October 8, 2018  
Revised: March 30, 2021  
Revised: August 5, 2021

Subject: Geologic Hazard Evaluation and Preliminary Geotechnical Investigation  
Haven Valley (formerly Patriot Village)  
Alturas Drive and Cable Lane  
Security-Widefield, Colorado  
CTL|T Project No. CS18980-115

Sheet 1 - Description, Dedication, Notes and Certificates Sheet 2 - Plat Graphic, Lots & Tracts

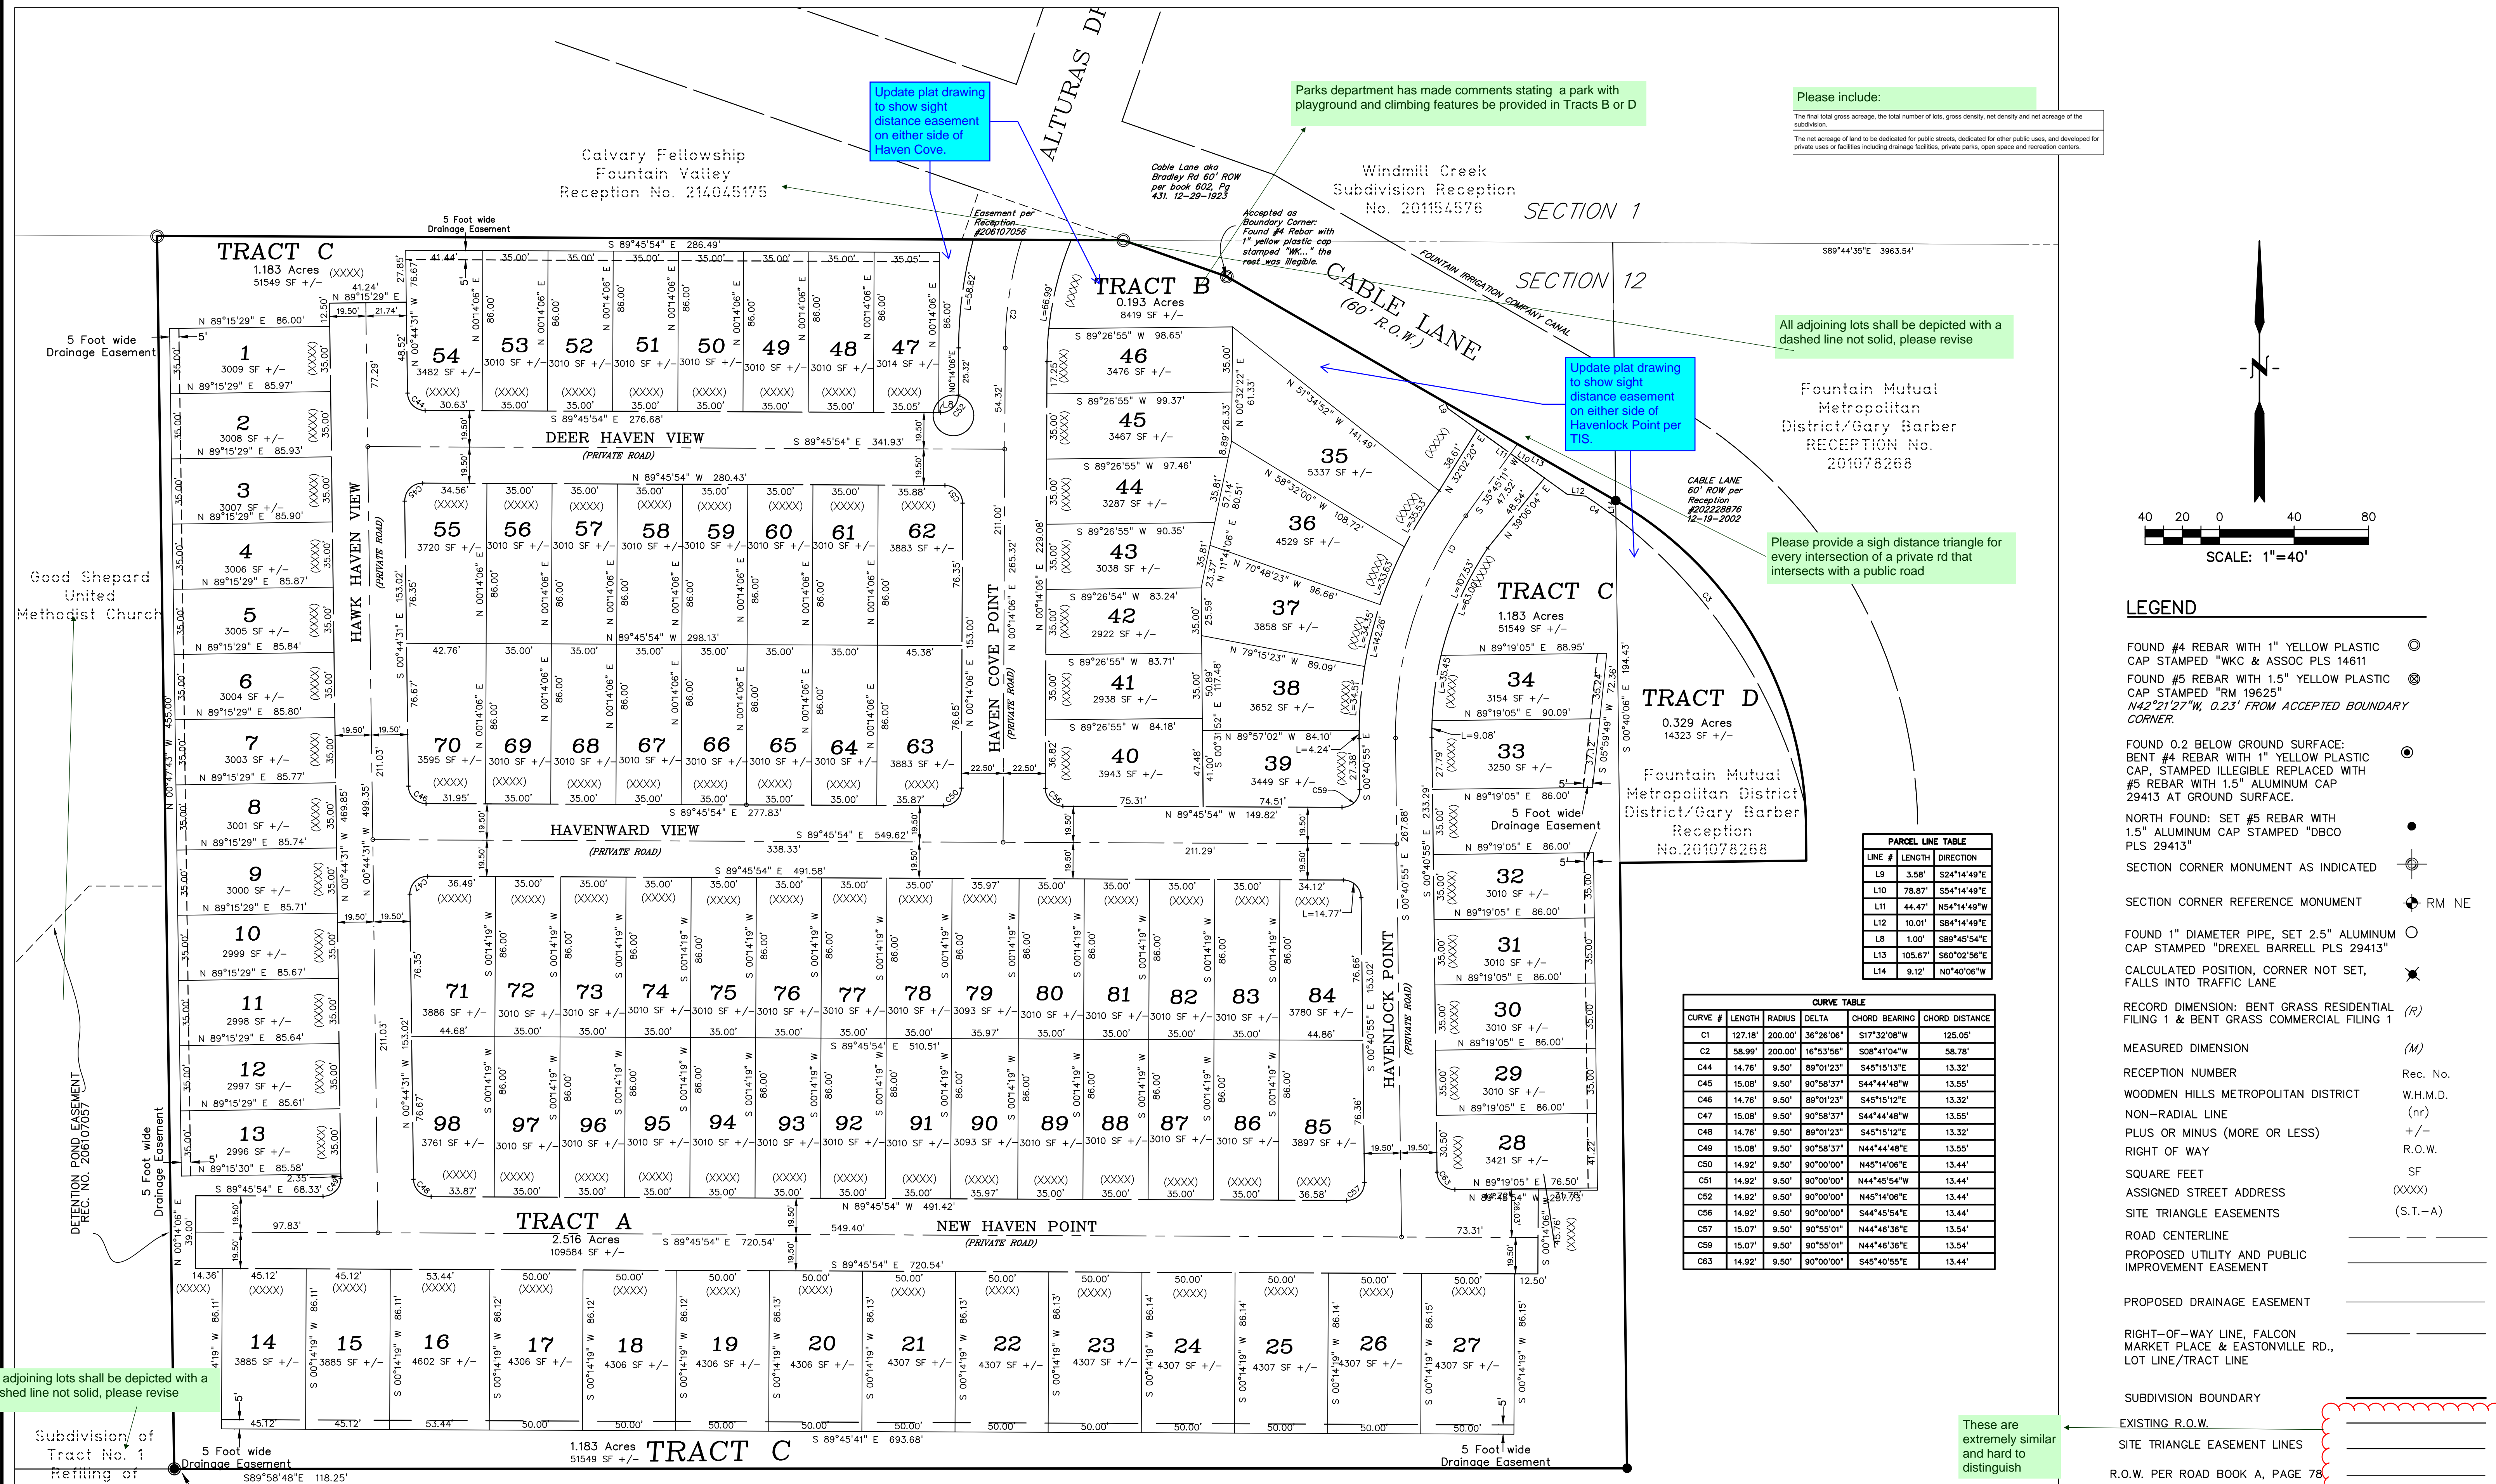
The geo hazard note on the plat should reference this, "see page 5-9 for more information about undocumented fill and special precautions to take"

this should be added within the geo hazard note as well
